Marine
Management
Organisation

MMO Reference: DCO/2022/00007
Planning Inspectorate Reference: EN010125
Identification Number: 20050160

Planning Act 2008, RWE Renewables UK Dogger Bank South (West) Ltd and RWE Renewables UK Dogger Bank South (East) Ltd Proposed Dogger Bank South Offshore Wind Farms Order

Deadline 8 Submission

IHLS Temperature Data (2023)

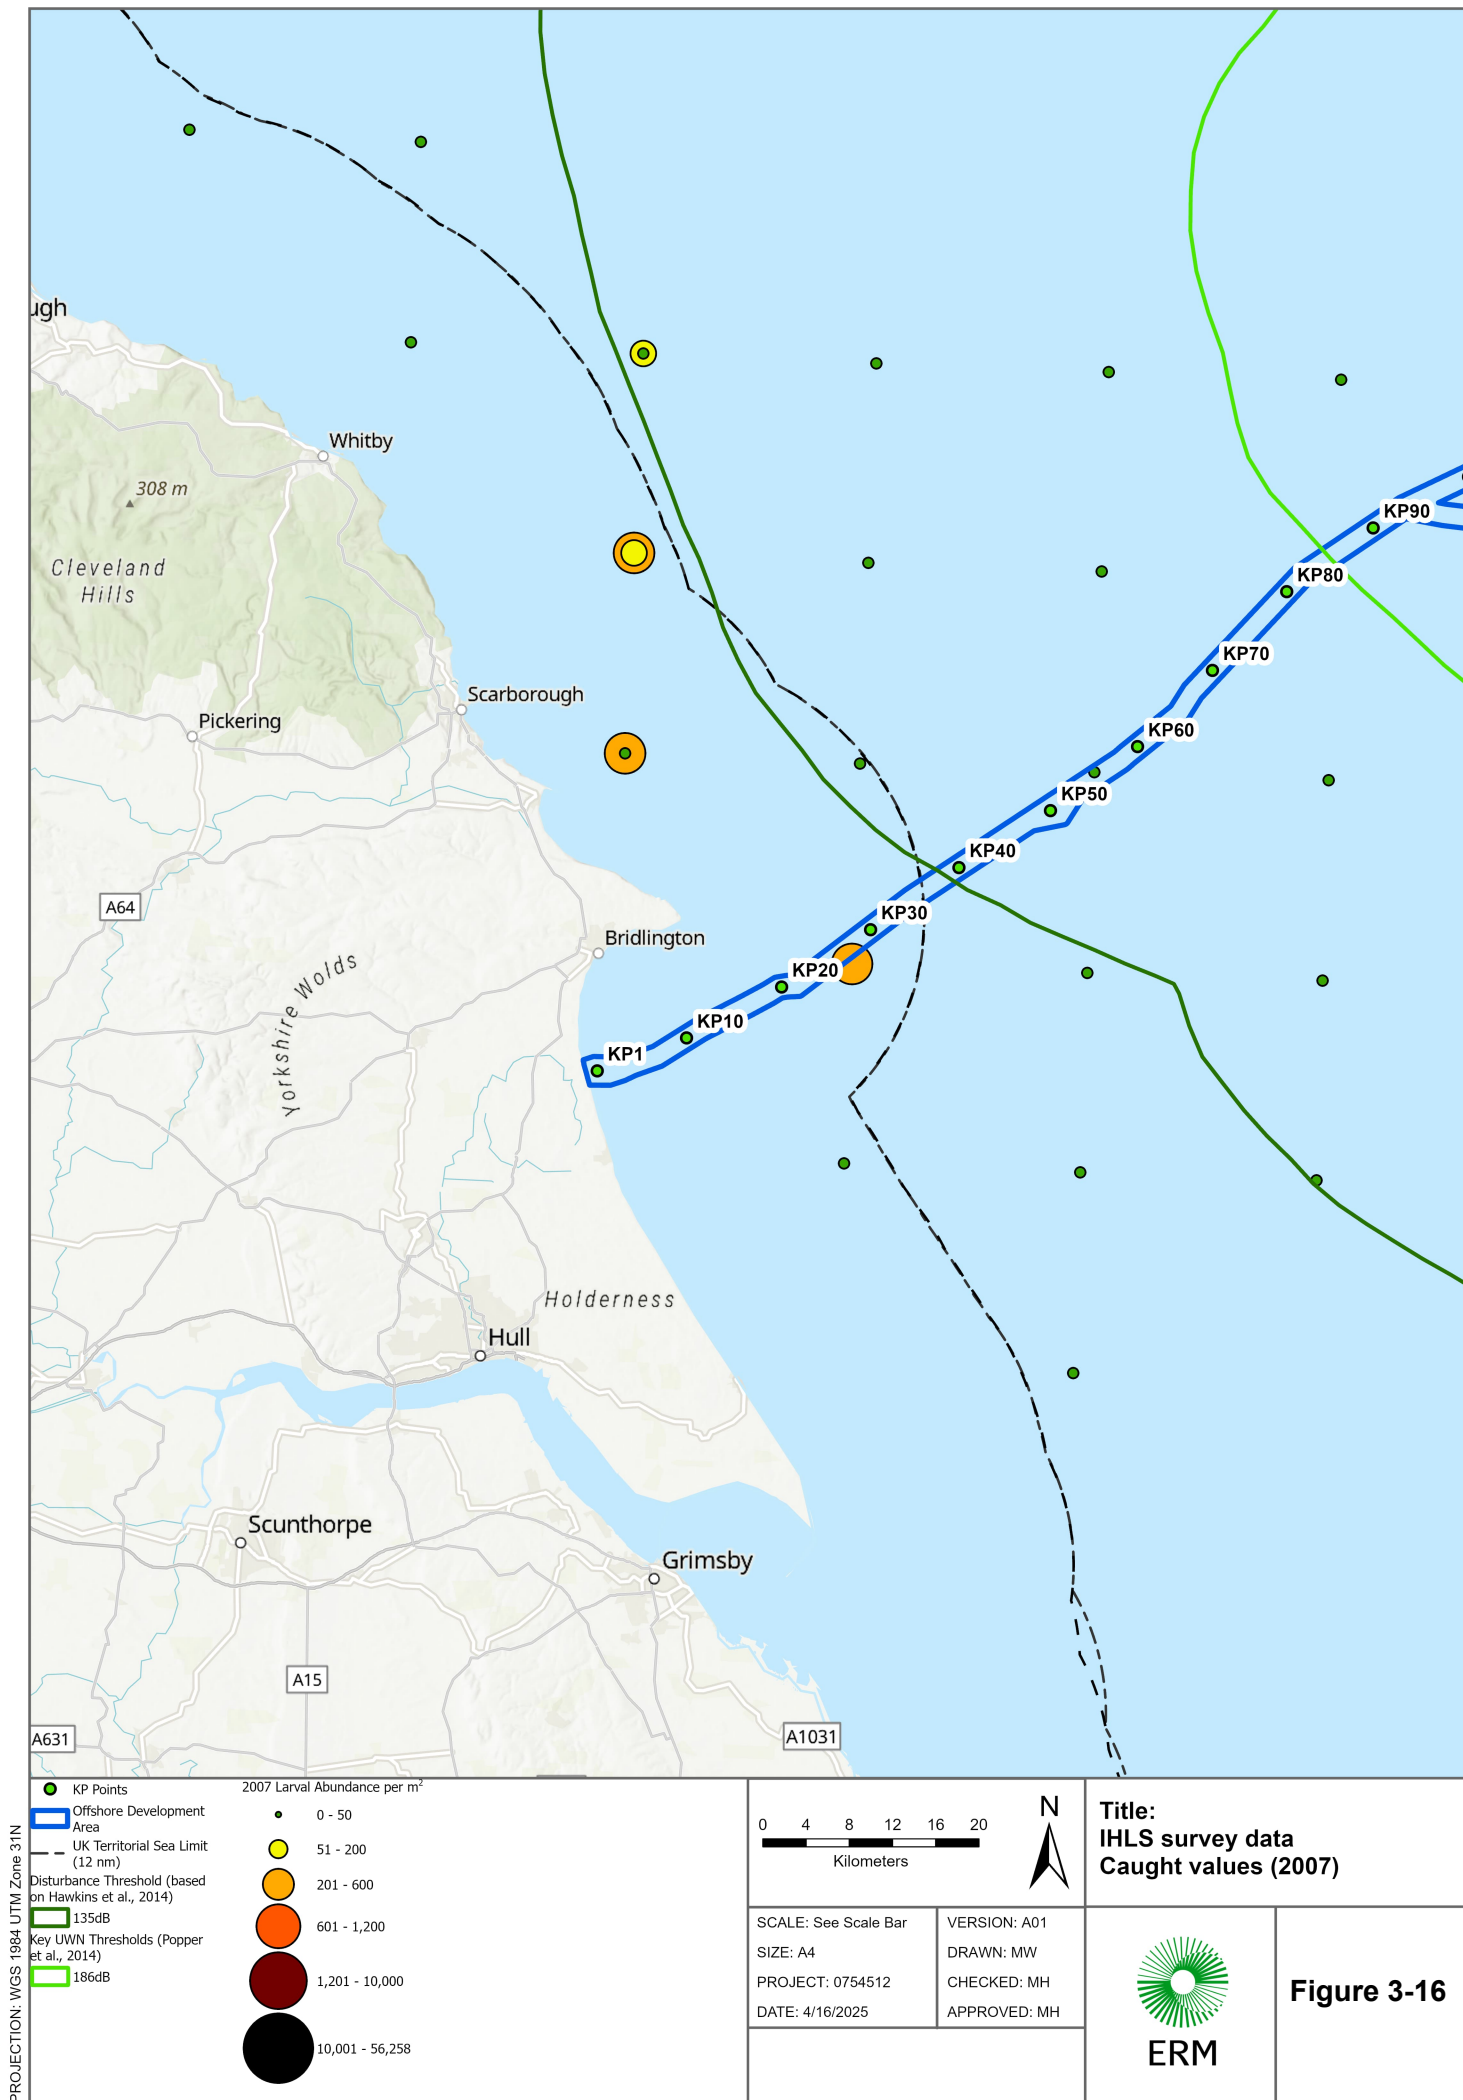
- 3.2.2 In Section 3.1, the Applicants state that "For the purposes of the back-calculation, the Offshore Export Cable Corridor is characterised by average temperatures >12.8°C". The near-seabed temperature data shows variation in near-bed temperatures for the International Herring Larvae Survey (IHLS) survey point within the ECC as being between 12°C Celsius (C) and >13°C, and the MMO does not believe that basing the back-calculation on average temperatures >12.8°C is appropriate as the data show periods where nearbed water temperatures have been lower than this, for example, temperatures of 12.01 - 12.30°C were recorded in 2012 and 2023.

To ensure that the Applicant's calculations are sufficiently conservative, the back-calculations should be based on near-bed water temperatures of between 12°C – 12.3°C as these are the lowest near-bed temperatures provided by the time series.
